OBJECTION

Development Applications SSD 8925

The new Sydney Fish Market - Stage 2

GLEBE WESTERN FORESHORE PATH

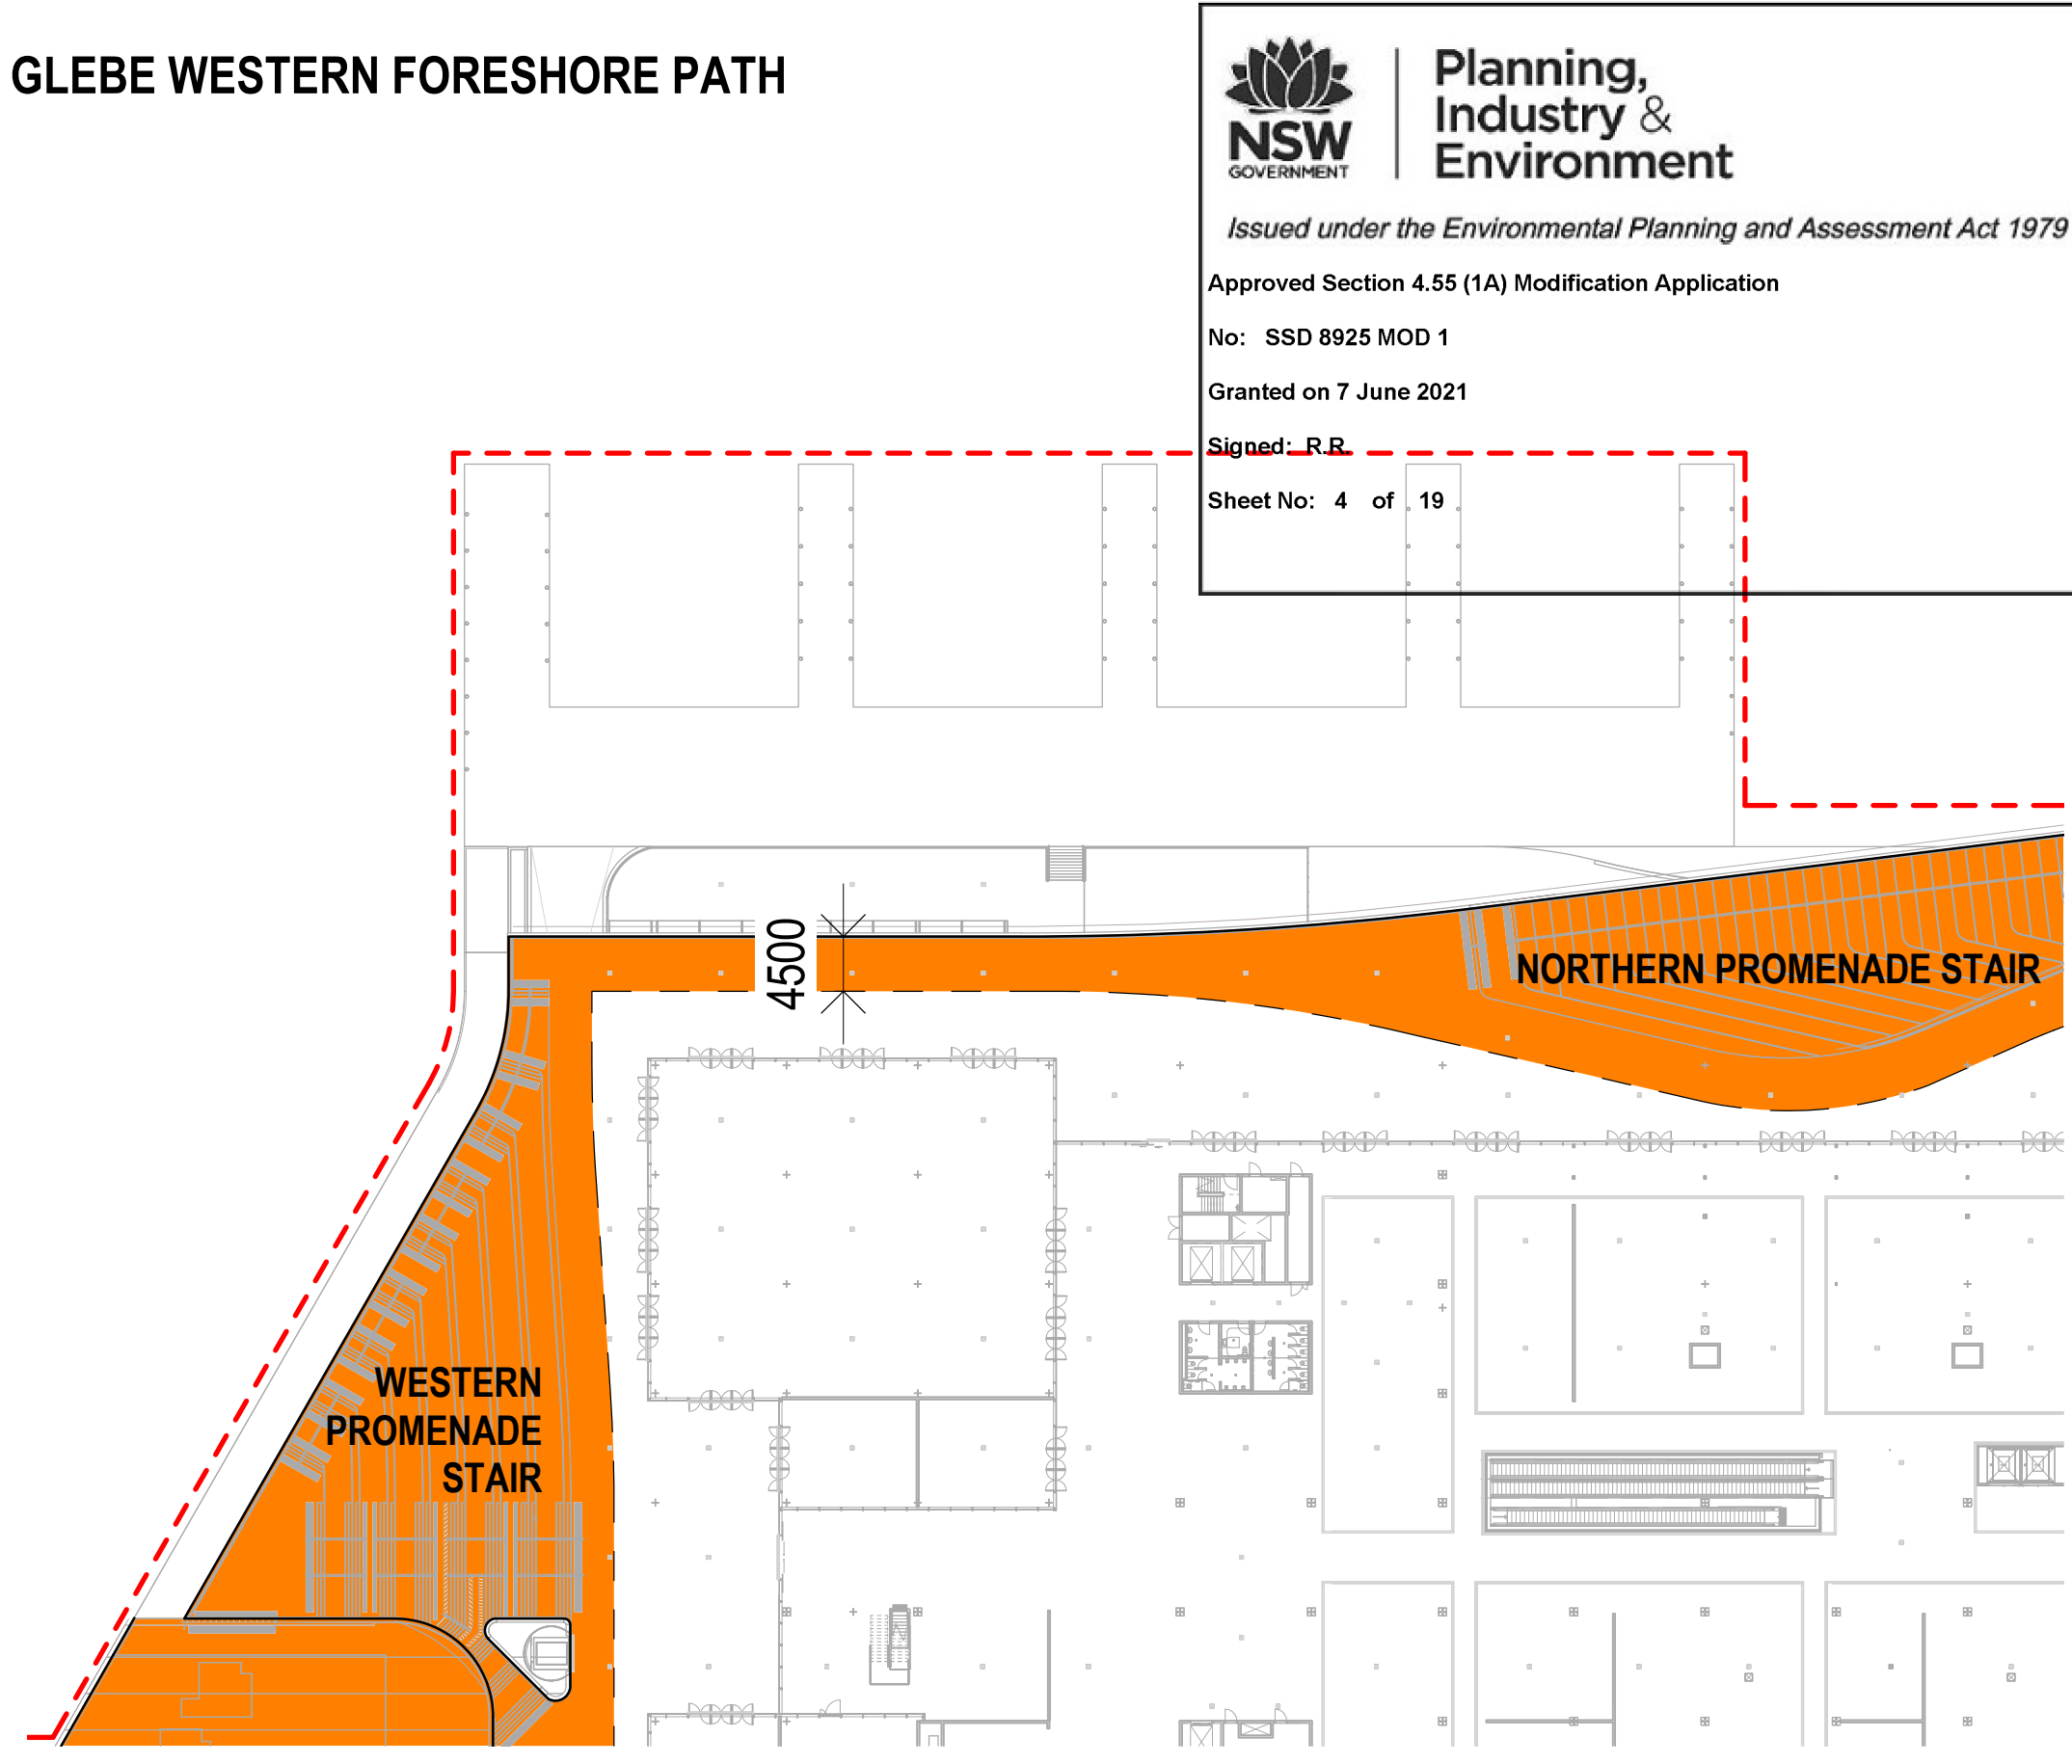
The promenade around the front of the SFM involves going up, along and then down two sets of steps. (*E.I.S. 3.5.3. p.29*).

TGS believes that the steps effectively discriminate against people who are reliant on wheelchairs. It will also create difficulties for parents and carers with children in prams, and people with young children riding bicycles, all using the Glebe Foreshore Walk in large numbers.

People using wheelchairs when travelling from Glebe must deviate from Bridge Road to access the lift that will take them up to the next level where they can re connect with the promenade. Those travelling in the reverse direction also need to access a lift down to the next level. This arrangement creates many potential problems for people with mobility impairment, both social and physical, as lifts break down, security risks increase, and most importantly, it is discriminatory.

TGS believes the current design of the promenade is not equitable, and that it appears to contravene the DDA. TGS objects to such a significant walk going through a building under the control of the SFM management. TGS also fears the SFM management could close the walk down if there were safety or security concerns.
